Application Reference: 2025/0715

Site Address: 5 Bude Court, Monk Bretton, Barnsley, S71 2QP

Introduction: Erection of two storey front extension to dwelling

Drawing No.	Rev No.
MMC001 -003	A

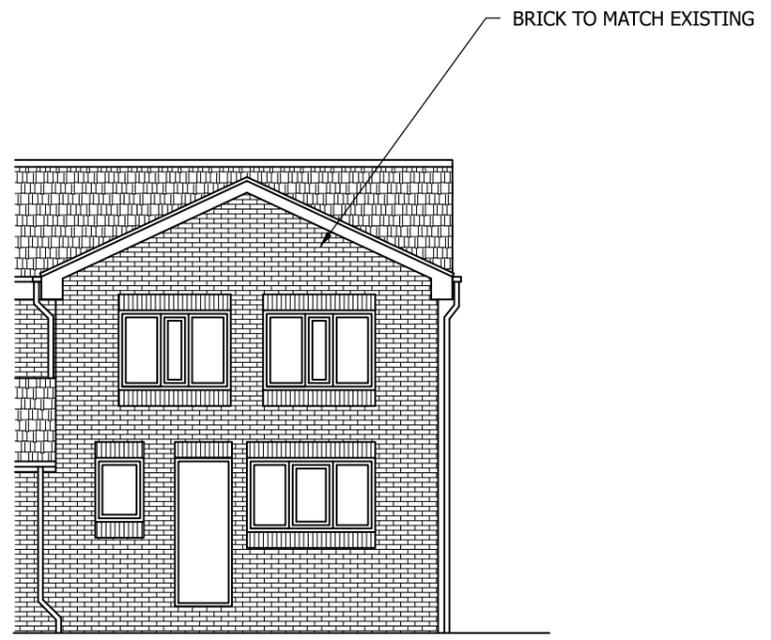
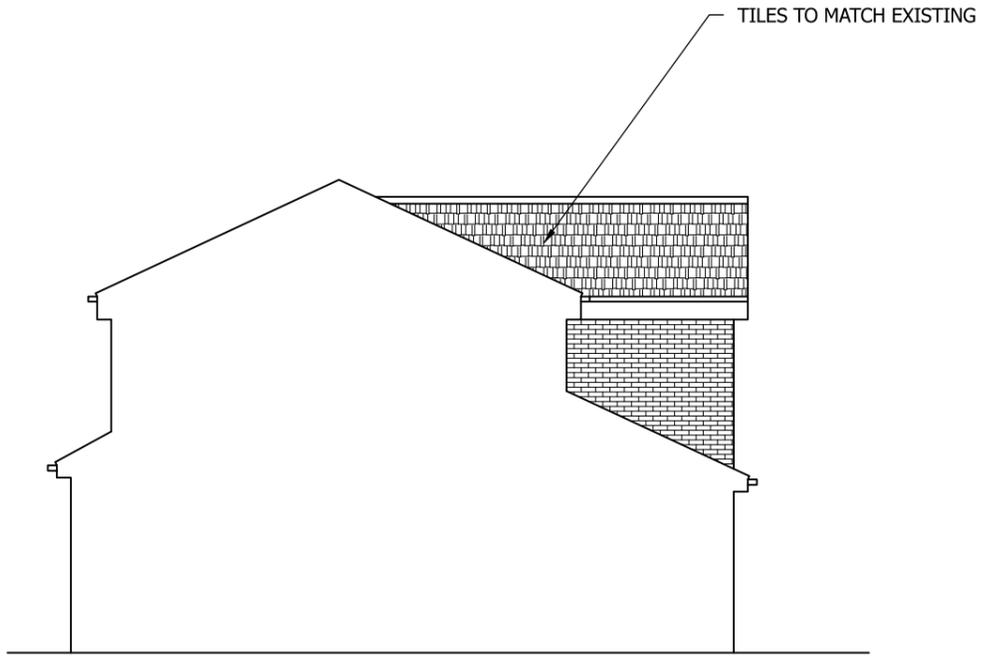
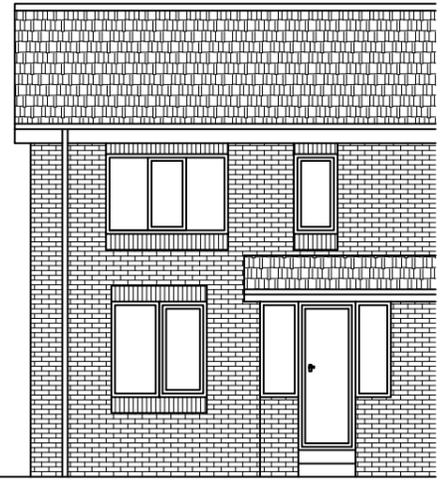
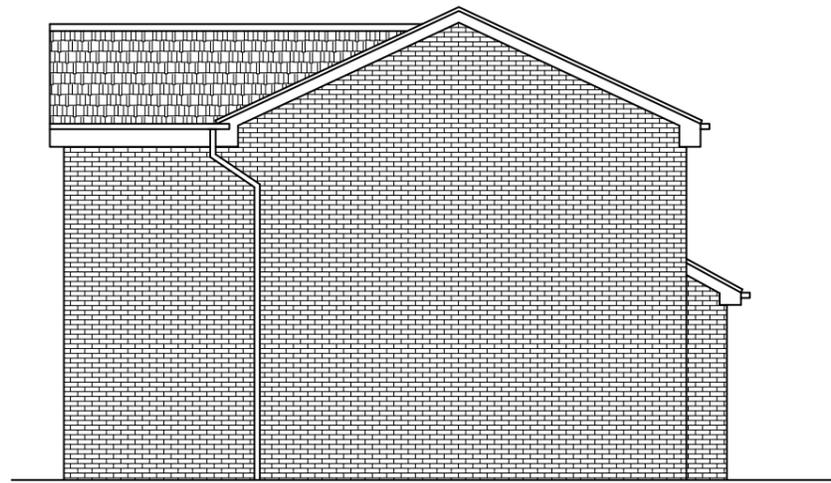
Glazing servicing the first-floor front bedroom is replicant of the existing first floor front bedroom glazing. Glazing to service the first-floor bathroom is increased in size over the

existing bathroom windows, however, is not considered to detract from the character of the dwelling and does in fact provide a more symmetrical feel to the dwelling. In addition, this feature could be altered under Permitted Development. Glazing servicing the bathroom will be conditioned to be obscured glazing in order to protect the privacy of both the applicant and the public.

Ground floor glazing is proposed to service a Diner/Kitchen room. The size and scale of this window is an increase on the existing windows, however, does not detract from the character of the dwelling. The glazing does provide a more symmetrical frontage to the dwelling and allows for more light into the property. Glazing has been proposed to service a ground floor toilet. This glazing will be conditioned to be obscured glazing in order to protect the privacy of both the applicant and the public.

The proposed front door has been positioned in a location replicant of the existing front elevation. This assists in ensuring elements of the proposal remain in keeping with the original dwelling and the character of the site and street scene.

It has been necessary to make contact with the applicant to request amendments to the proposal to provide existing and proposed elevations which confirm the position of the proposed front door.
